Development	Proposed development of a 110kV/20MW distribution station
Location	Fostertown, Caberstown, Trim, Co. Meath
Planning Authority	Meath County Council
Applicant(s)	The Electricity Supply Board
Type of Application	Application for approval under section 182A of the Planning and Development Act, 2000 as amended.
Prescribed Bodies	Department of Housing, Local Government and Heritage Transport Infrastructure Ireland
Observers	None.
Date of Site Inspection	08 th October 2025.
Inspector	Paul Kelly

The project is called the “Fosterstown Distribution Substation” and its objective is to add capacity and improve distribution security of supply for the Trim area, Co. Meath.

**ELEVATION OF FENCE**  
SCALE 1:50

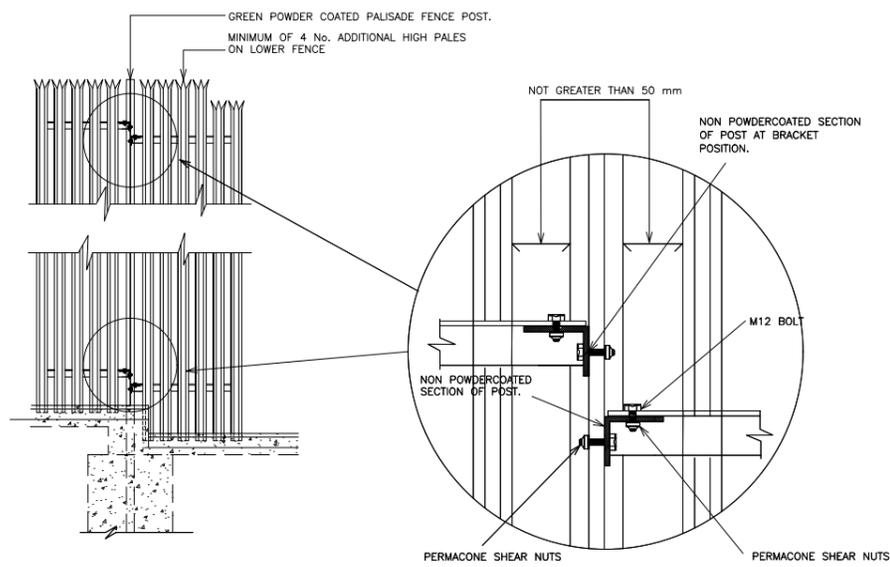
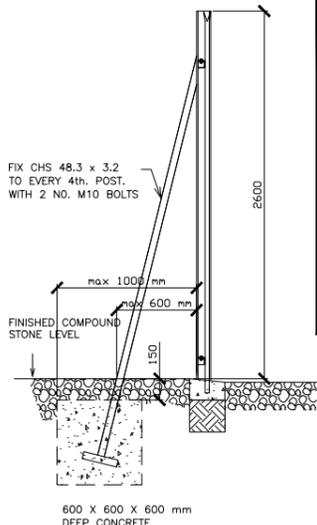
Internal reports received from the MCC Transportation and Environment Sections state no objection to the proposed development from a roads and traffic safety, flood risk and drainage perspective. The report welcomes the applicant's proposal to retain the existing derelict cottage, which is located within the subject site, and opines that an alternative boundary treatment to the proposed palisade fencing should be sought on the basis that it would be visible to the public and inappropriate in a rural setting.

9.3.10 I do not share the view of MCC that the palisade fencing will be visible to the public and is inappropriate in a rural area. The palisade fencing is proposed to the substation compound only and is likely necessary for overriding health and safety reasons. Notwithstanding this consideration, it is set back approx. 160m from the public road at its closest point and in this position will be ameliorated satisfactorily within the landscape in a manner consistent with the larger substation structures and the findings of the LVIA. In my view the palisade fence cannot be discreetly selected as an objectionable element of the development in this context.

Furthermore, the landscape mitigation plan proposes for a 10m riparian zone on the eastern and northern site boundaries (outside the palisade fencing), retention and augmentation of the hedgerow boundaries at this location and a native woodland of 906 sq.m (*DWG. No. LD.FSTRSTWN-SBST 1.0 refers*) which will serve to screen the palisade fencing. Otherwise, the boundary fencing of the site which will be visible from the public domain consists of a post & rail fence. Accordingly, I am satisfied that the palisade fence will not be visible, and an alternative fence type is not required.
